Sent: 10 May 2012 13:36
To: Planning
Subject: URGENT: FAO Mr Laird re 6 plans for Fordwich Road

I live at number 8 Fordwich Road, and the proposed extensions are for building work at 6 Fordwich Road, which is occupied by Mr and Mrs White.

**DRAWING TITLE**  
PROPOSED SINGLE STOREY SIDE  
AND REAR EXTENSIONS

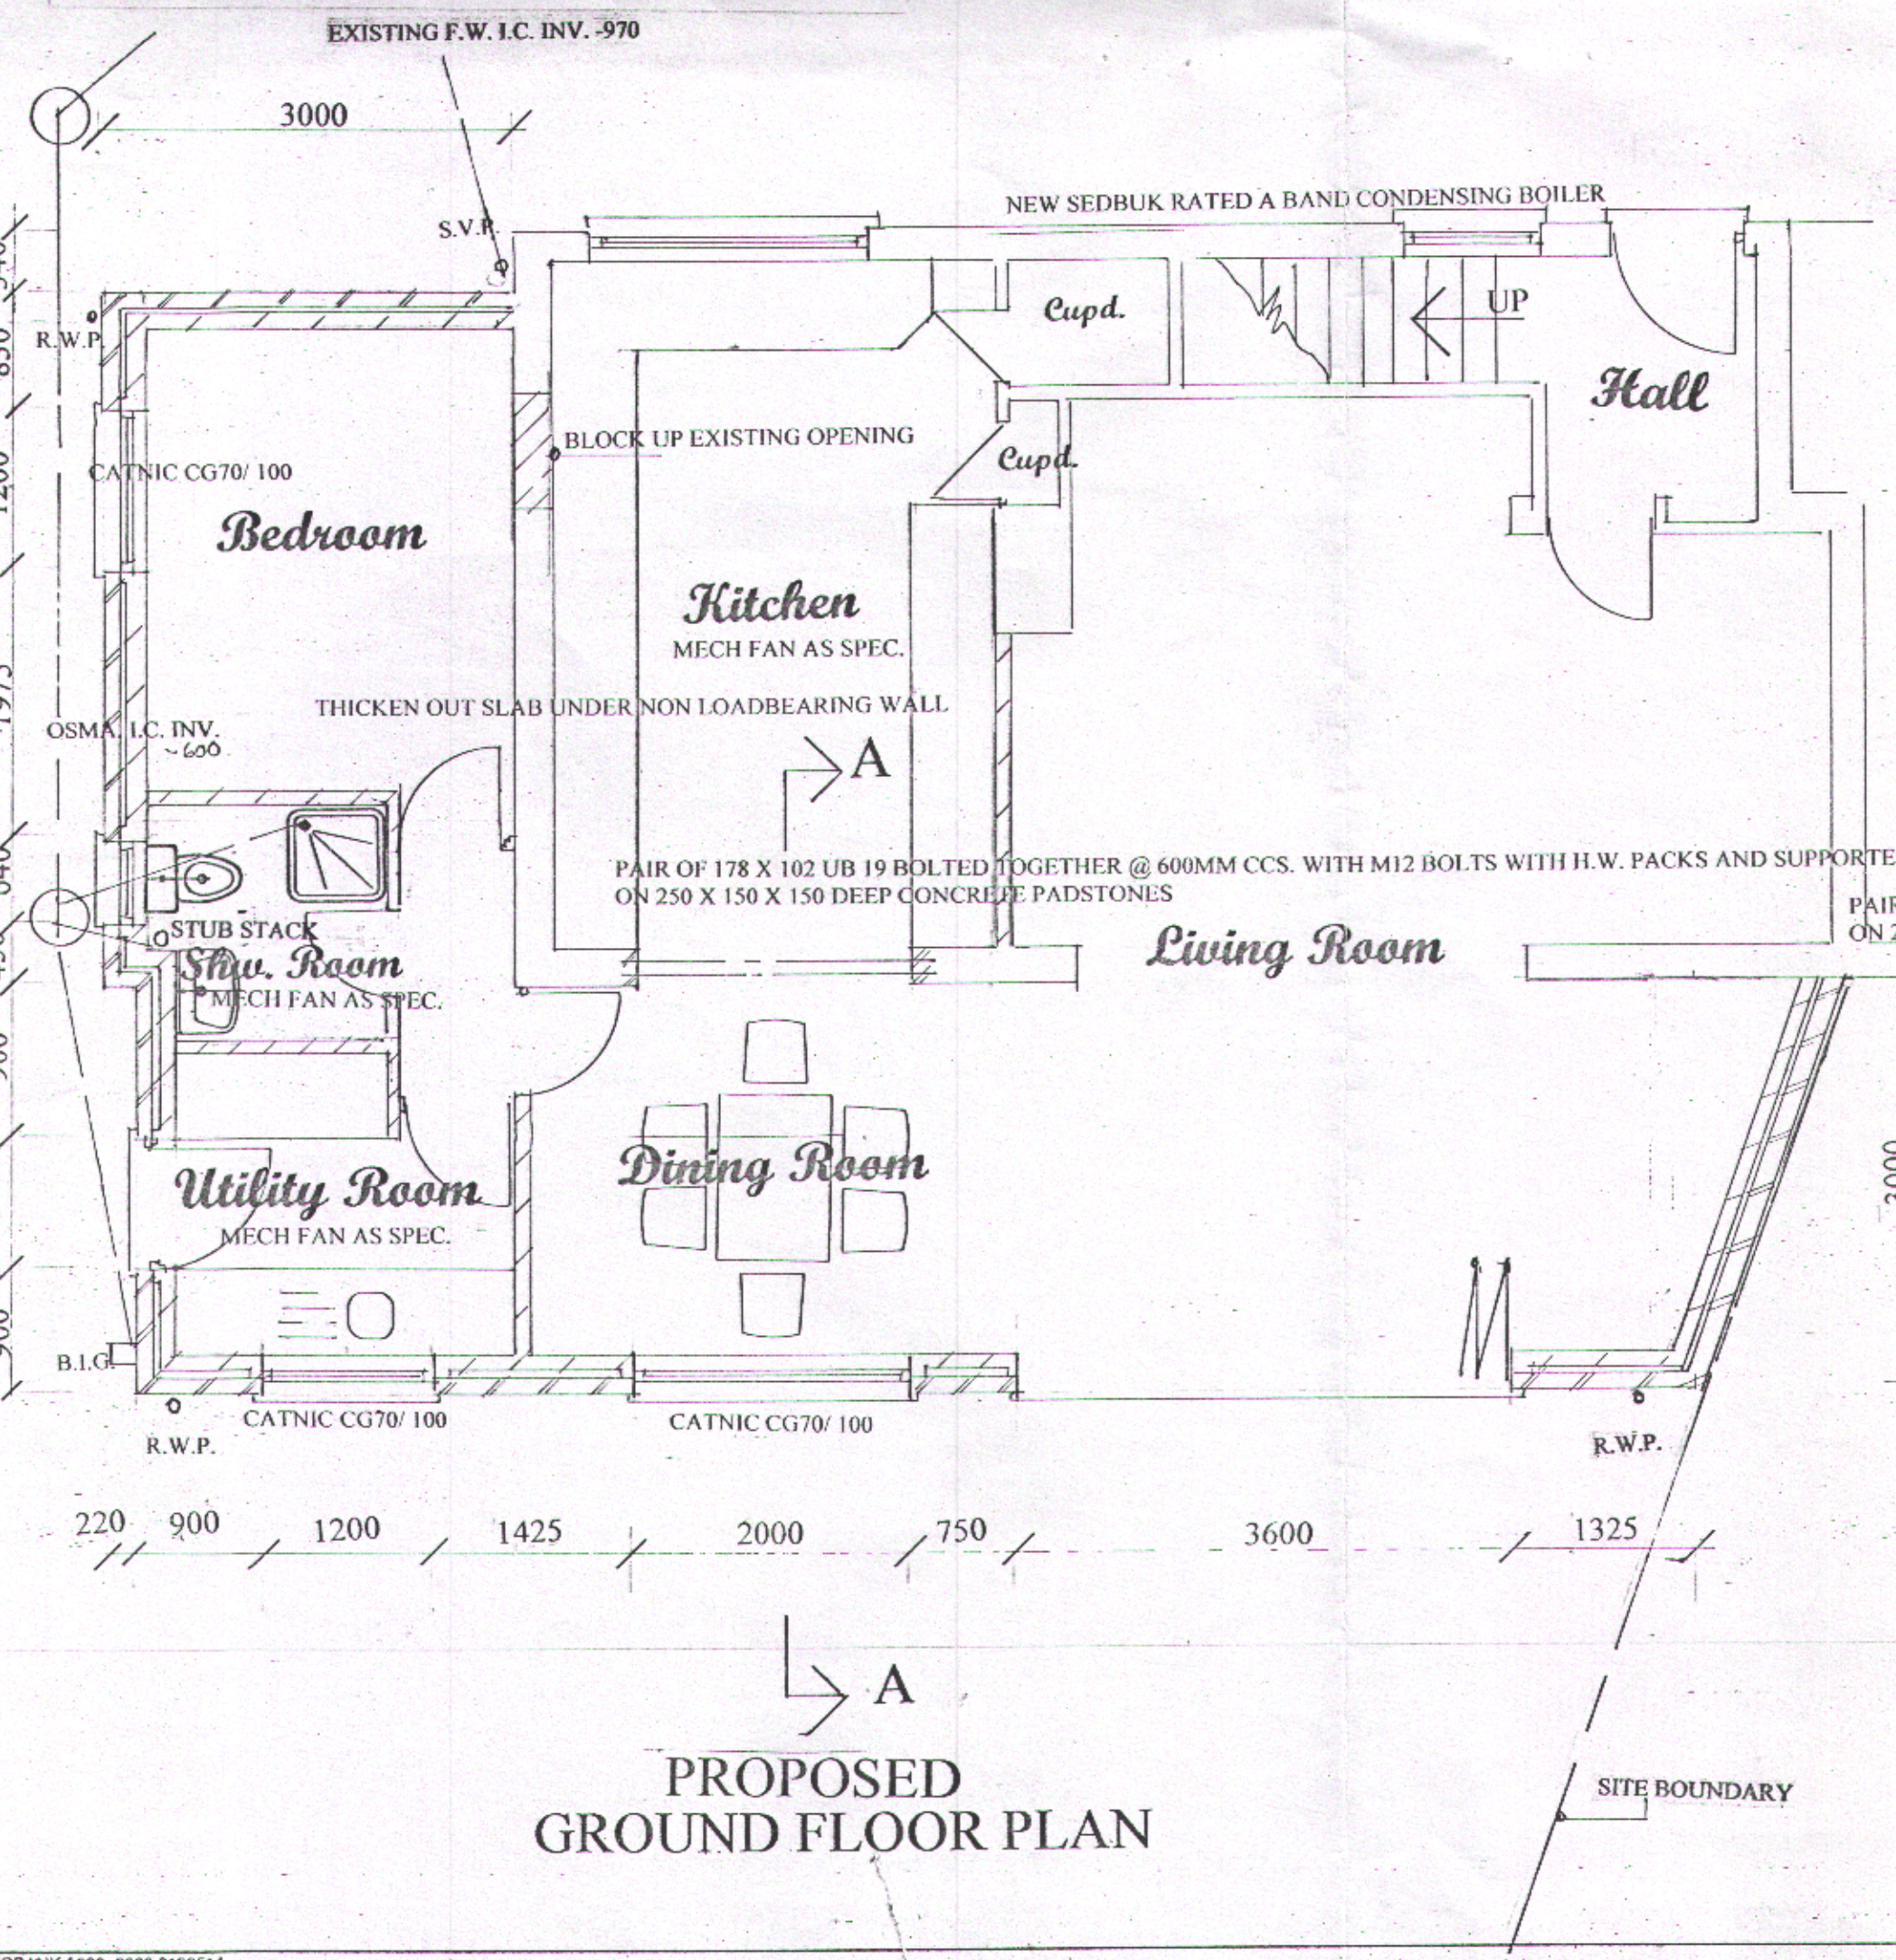
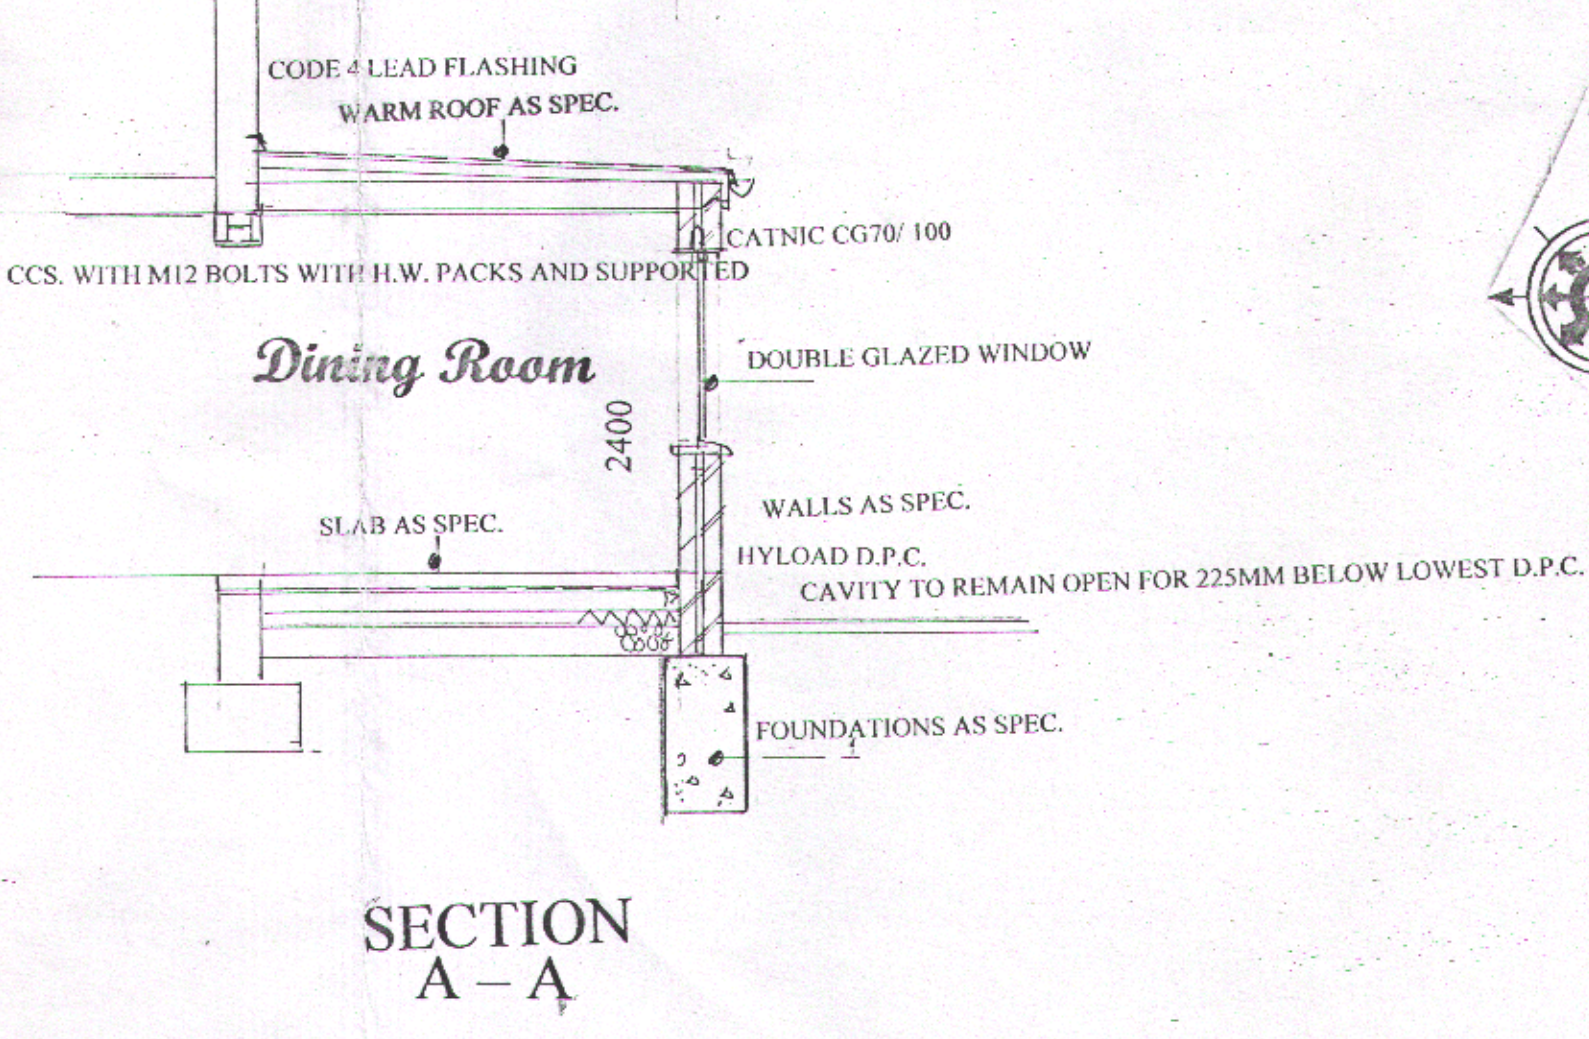
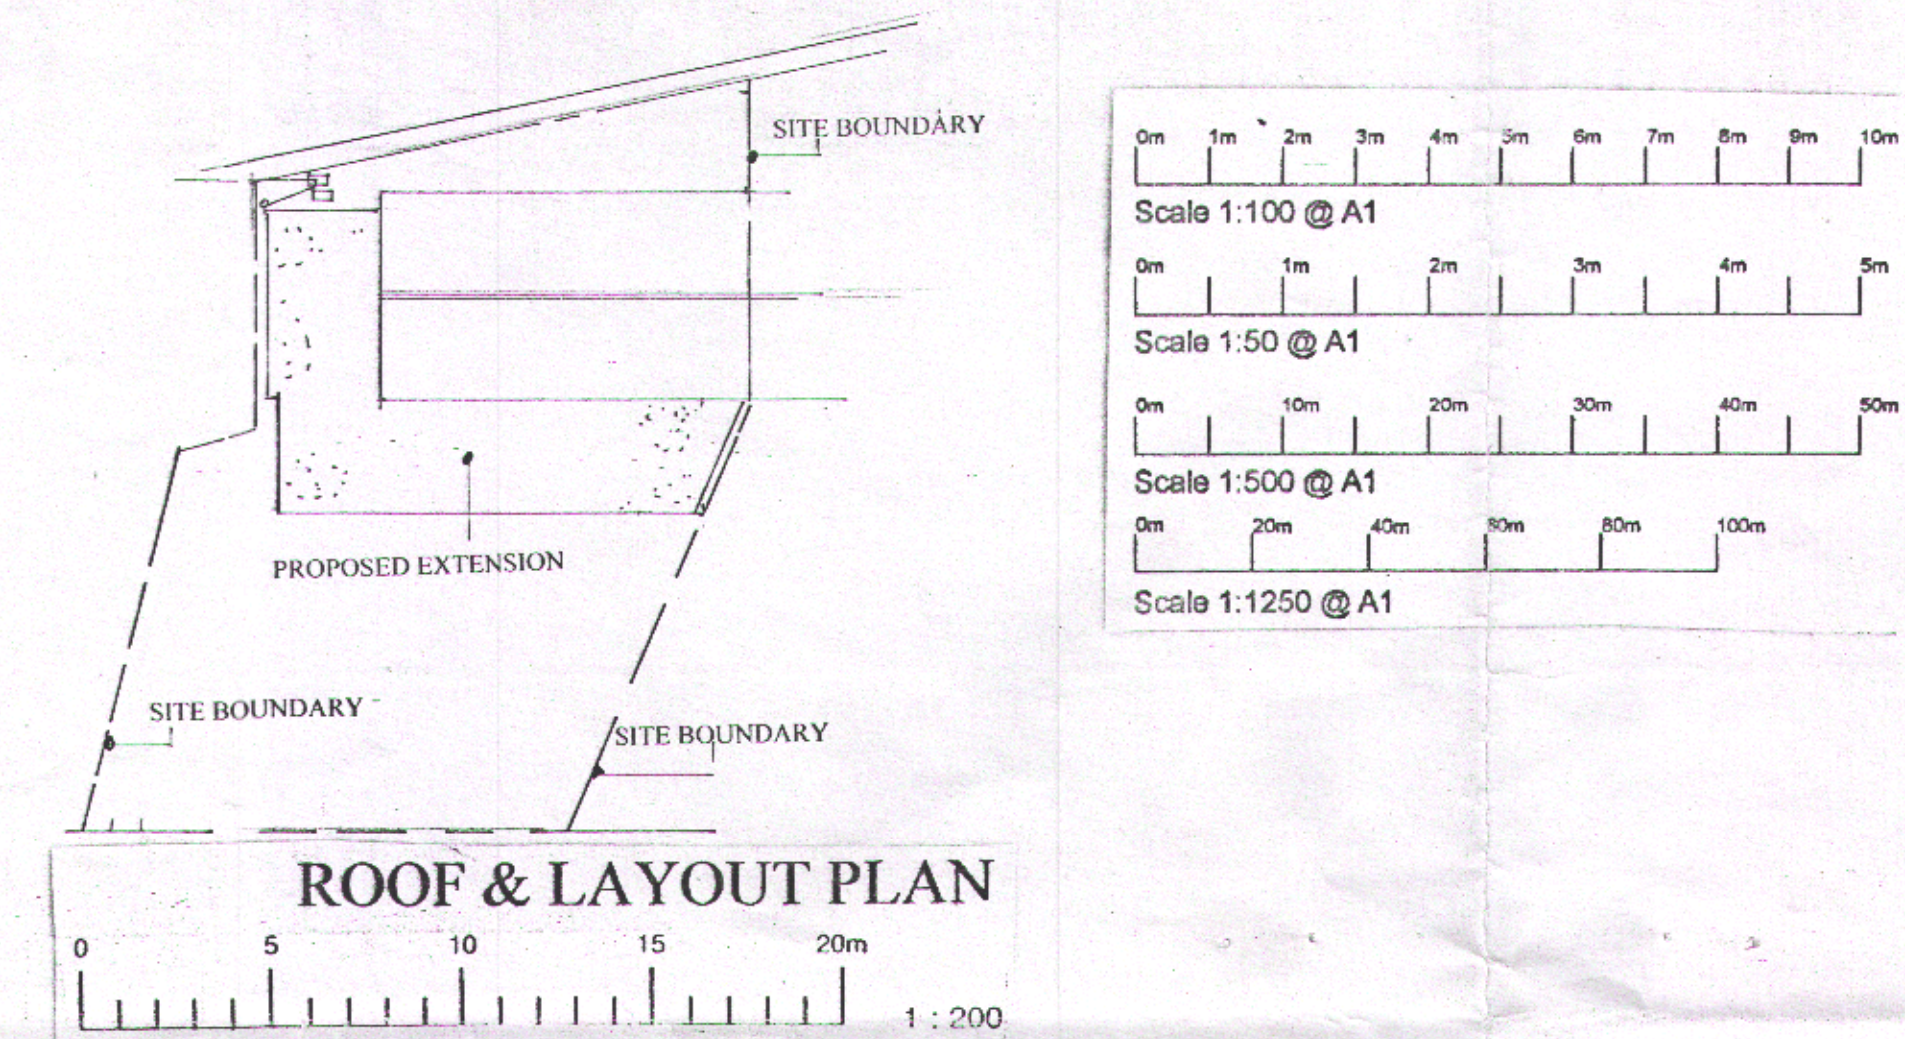
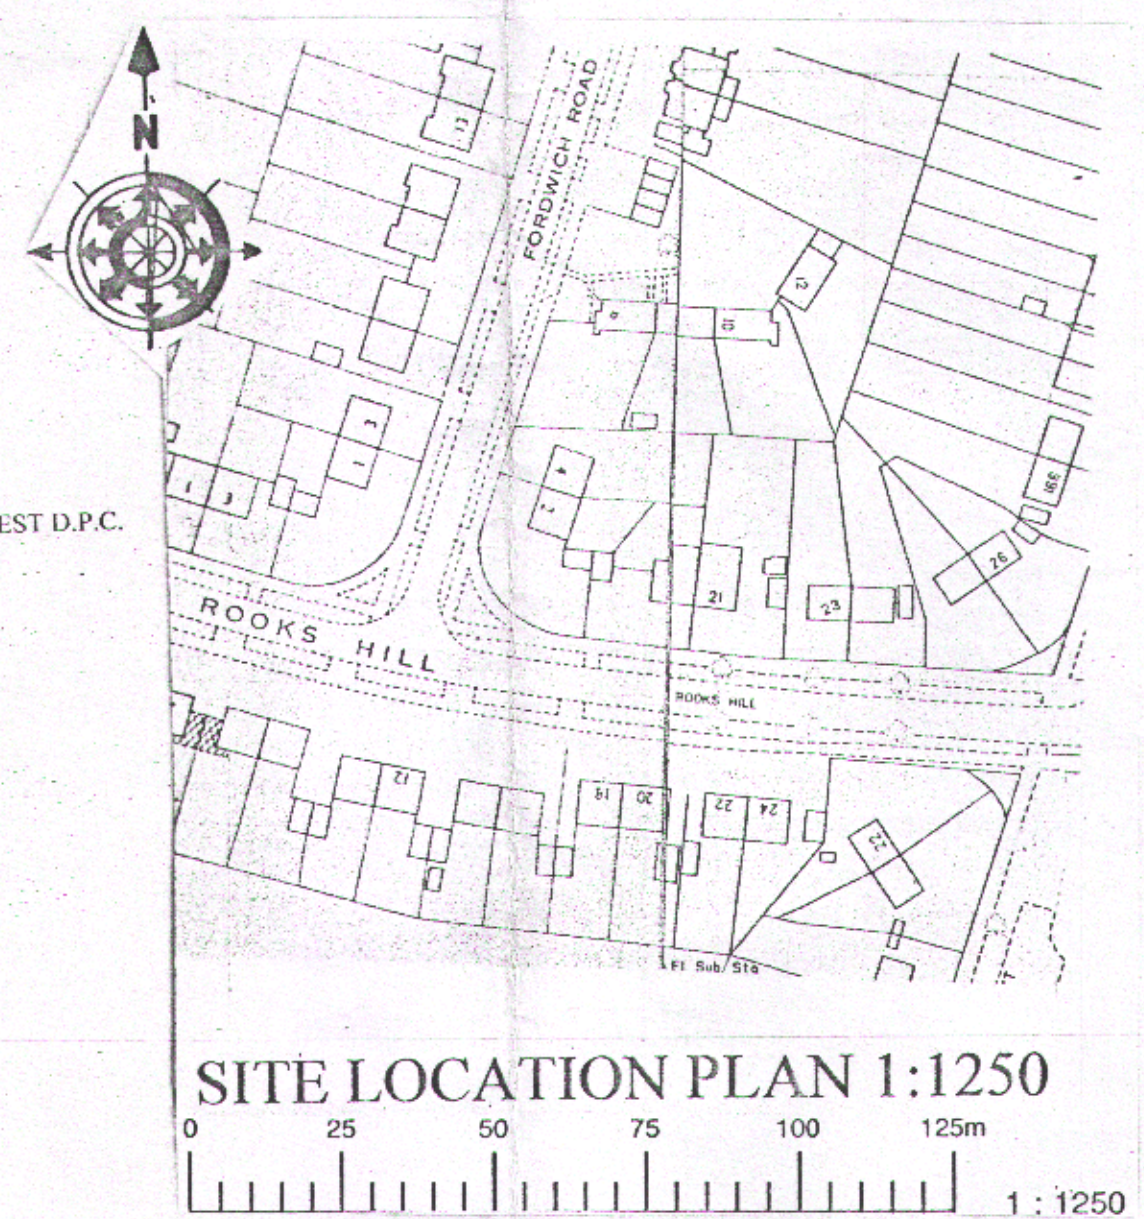
I object to these plans as they extend beyond the boundaries of the property on the west side, into the area of land that is a shared amenity for the 4 properties and not the exclusive property of the Whites. This would mean an unacceptable loss of amenity to the other 3 properties.

The boundary fence around the property does not extend for the 3 metres that they would need in order to build the proposed extension. The proposed extension, if built, would mean that the Whites have no longer any side access to their property and this would make a lot more demands on the main access to the building. Considering that there has been a long standing neighbour dispute, this would affect relations for the 4 properties.

The proposed extension would jut out well beyond the current boundary fence for that property. The scale of this proposed extension would mean that the house would be out of character with the rest of the neighbourhood and would result in a considerable loss of the visual amenity for the four properties in the scheme.
